Bradley Gasawski
Planner
Kittitas County Community Development Services
411 N. Ruby St
Ellensburg, WA 98926

Date: 8-19-2024

Re: Roslyn Ridge West Response to Comments

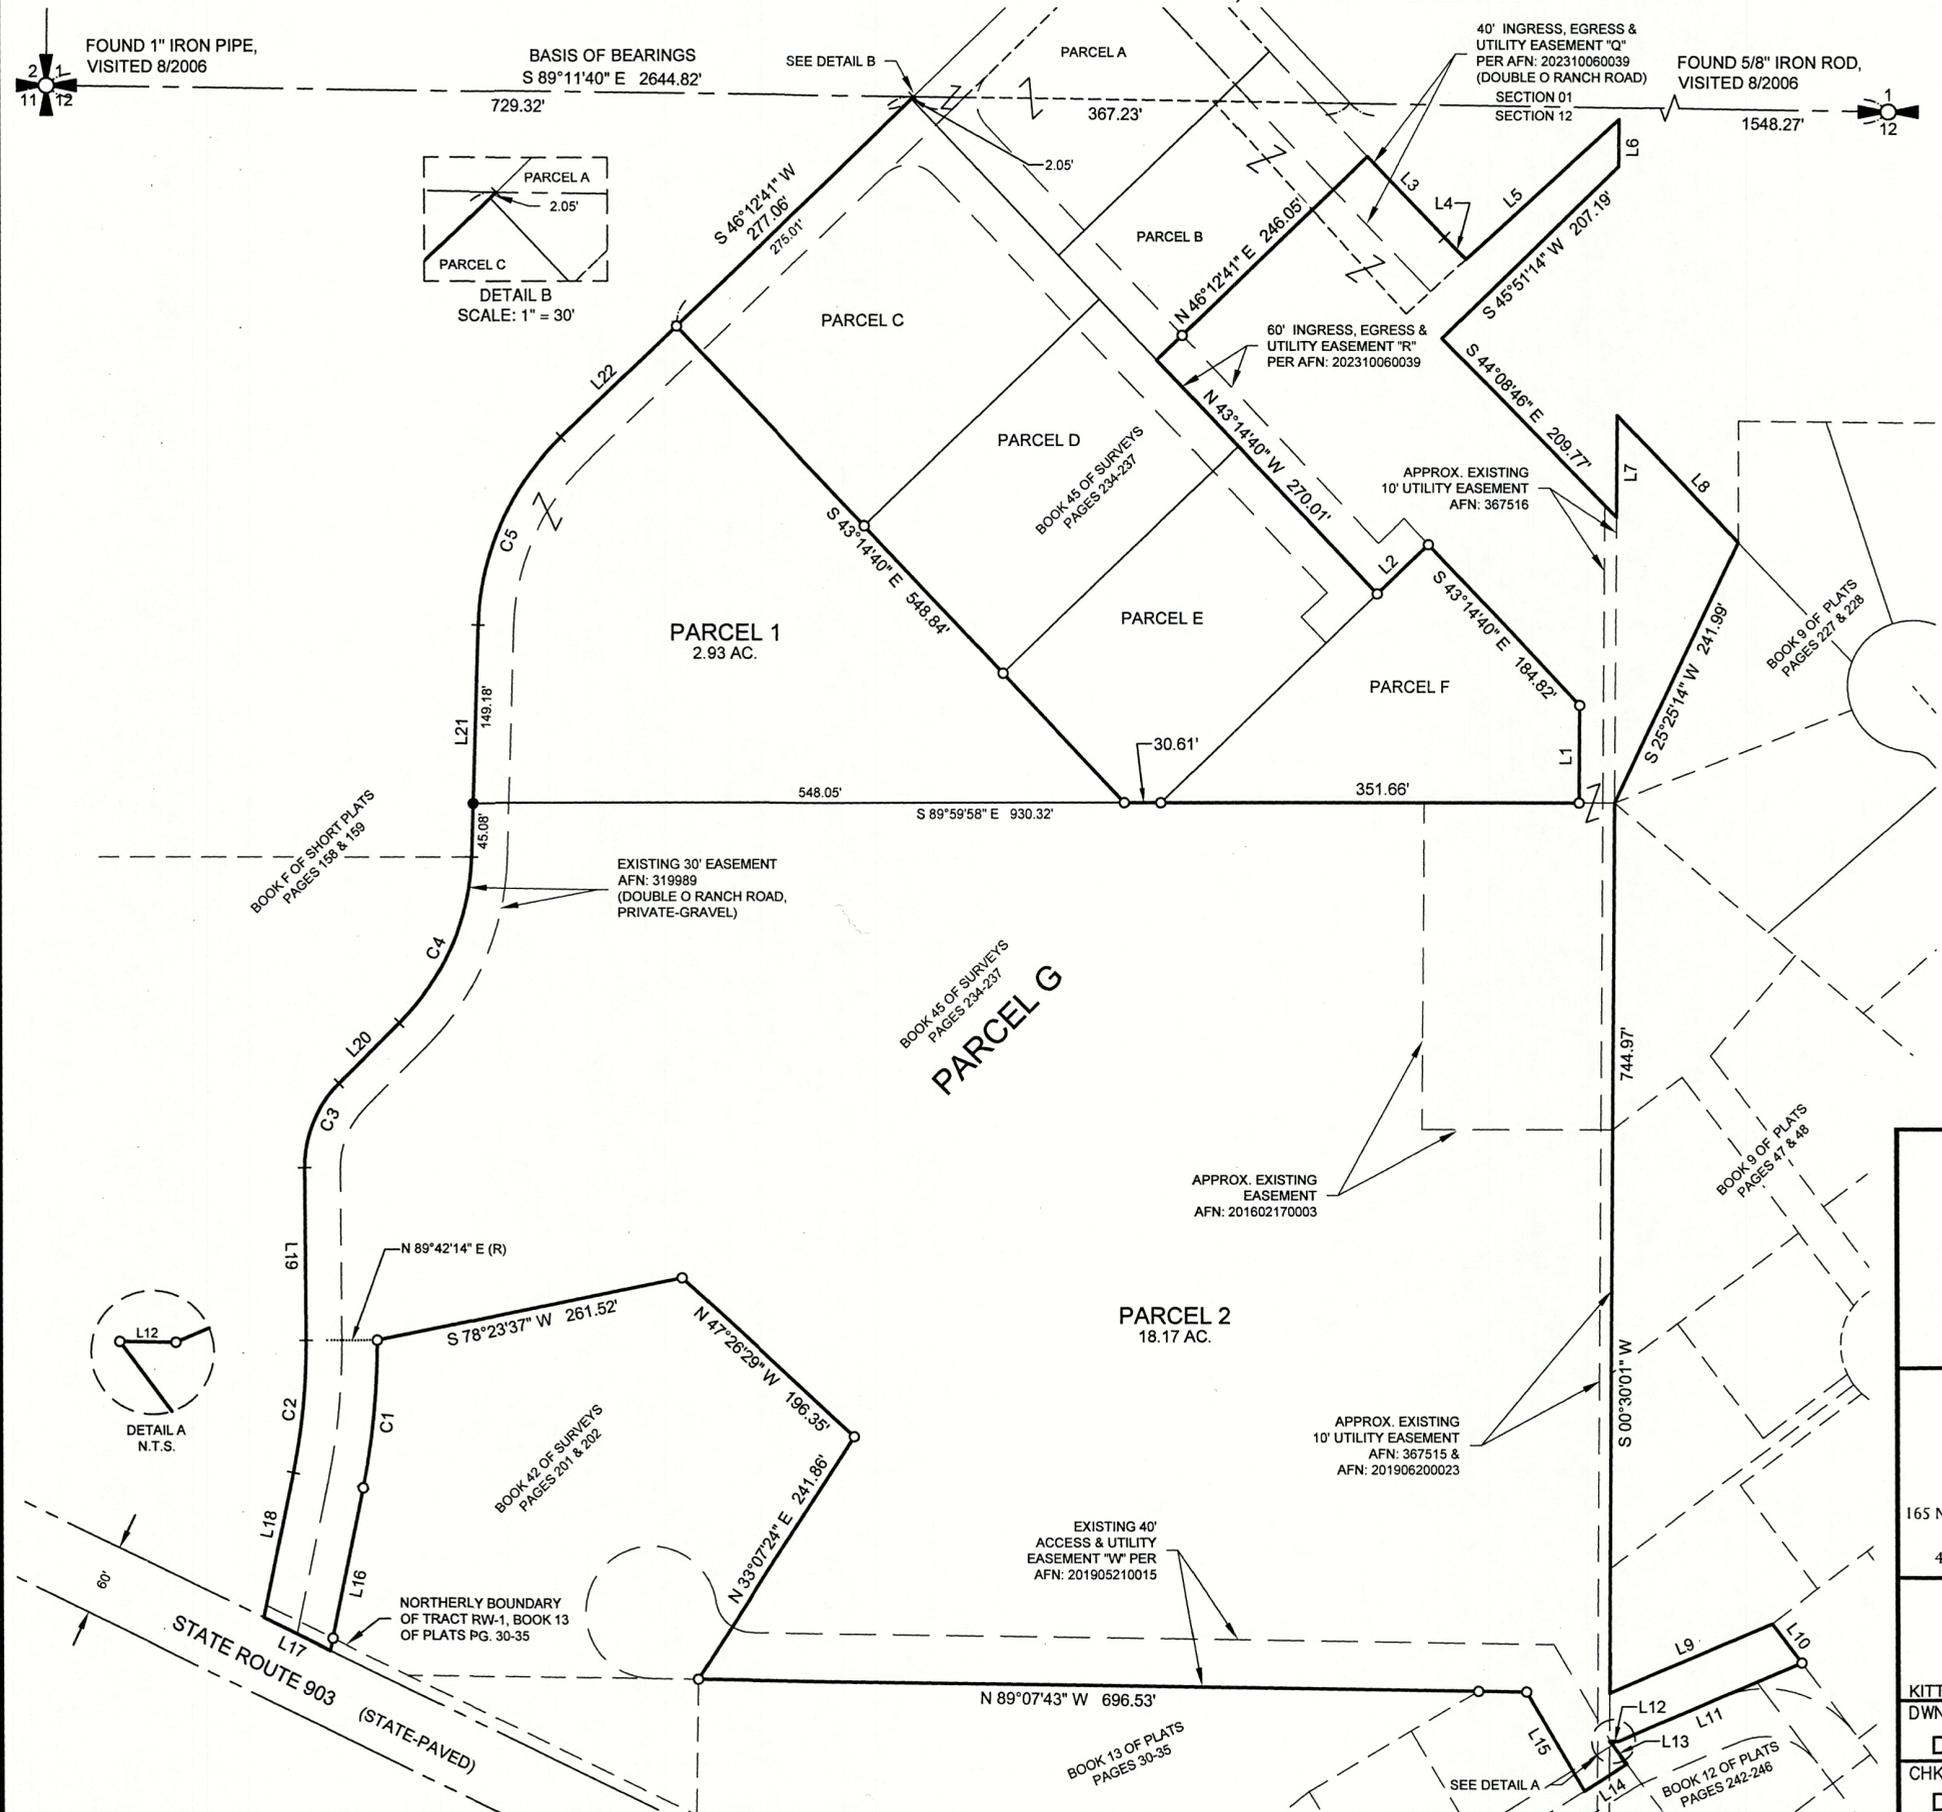
The first recommendation from WDFW's comment letter states: "WDFW recommends that all streams and their riparian management zones or buffers be identified on the plat maps; KCC 17A.04.030 identifies a 50' buffer on Ns streams. We also request that prior to any road building or grading near the streams, you contact WDFW to determine if a Hydraulic Project Approval (HPA) is required."

We agree to coordinate with WDFW by identifying the Riparian Management Zones and 50' buffers on our plat map. We will also contact WDFW for Hydraulic Project Approval (HPA) determination for the various areas within the project that might require an HPA.
